DRB CASE ACTION LOG (SDP – Building P.)

DRB Application No.: 08DRB-70036

Project Name: Original Townsite of Westland

DRB Comments

REVISIONS	DATE	ISSUED FOR:
		PERMIT
PLANTING PLAN		
SHEET NO:		<b>L2</b>

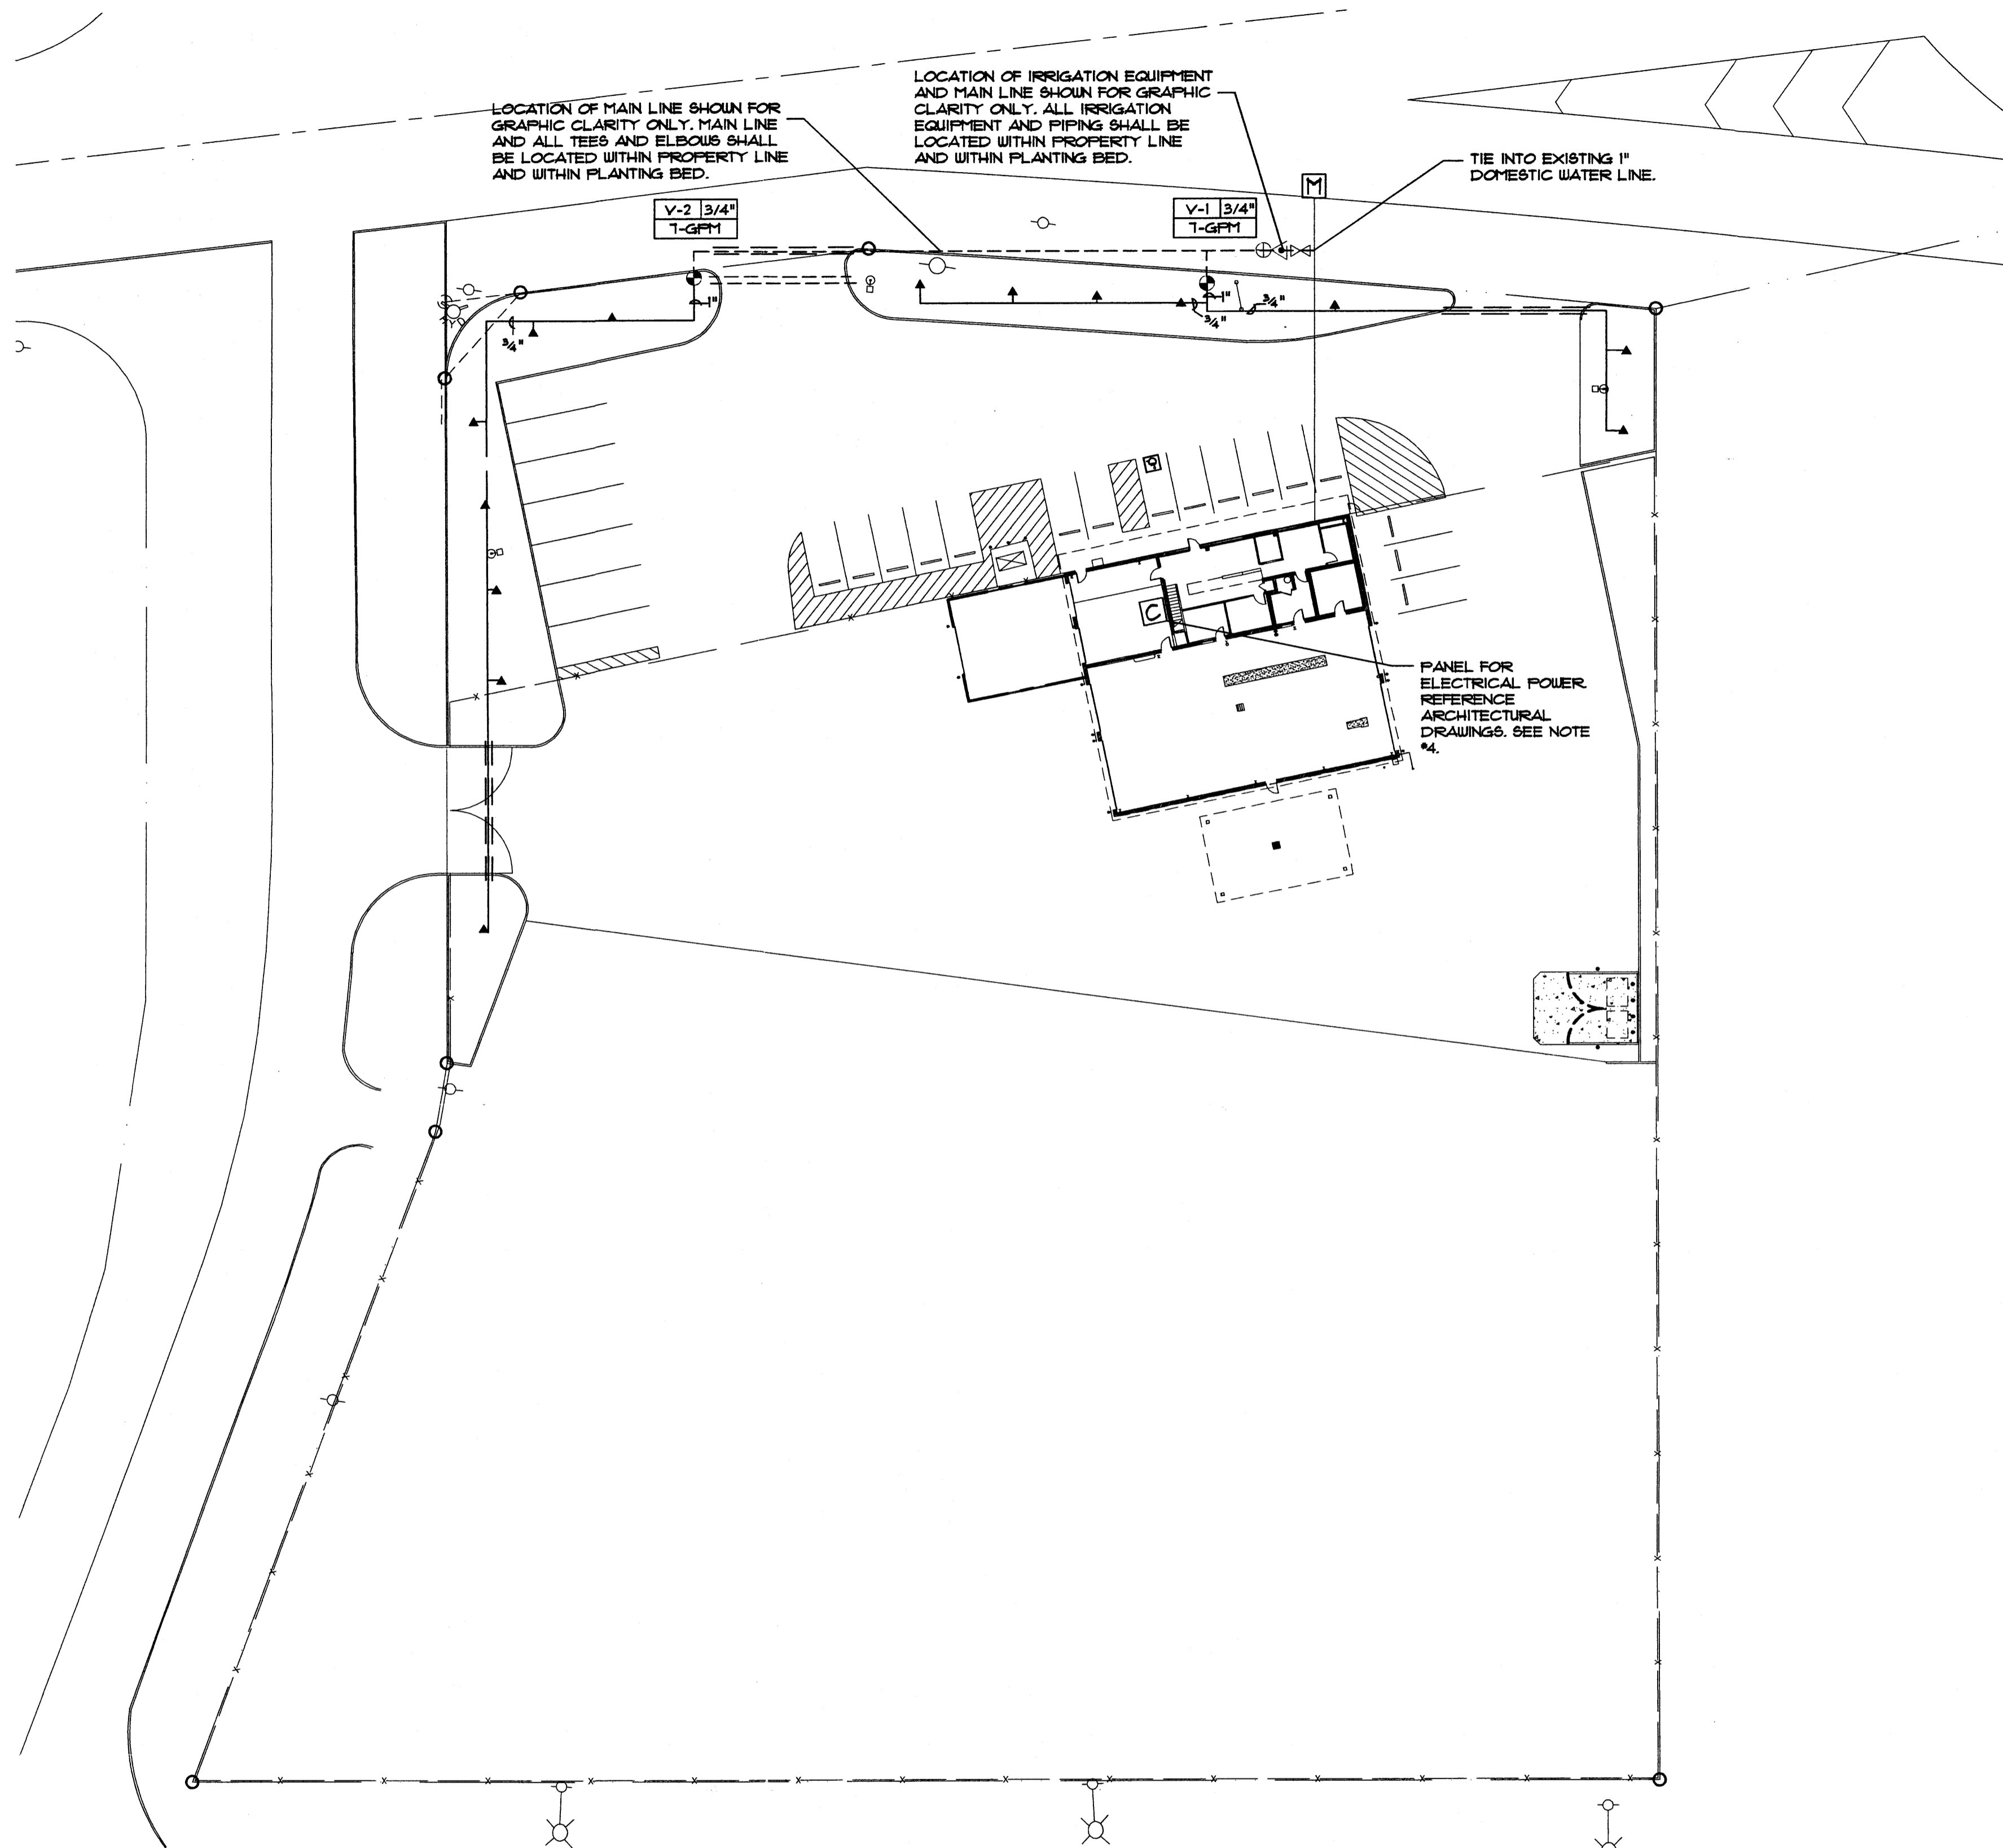
PLANNING (Last to sign): - full landscape plan on site sheet

The Landscape Plan needs to comply with Section 14-16-3-10 of the Zoning Code – live ground cover needs to be included. Additionally, the entire street frontage of 94th Street needs to be landscaped.
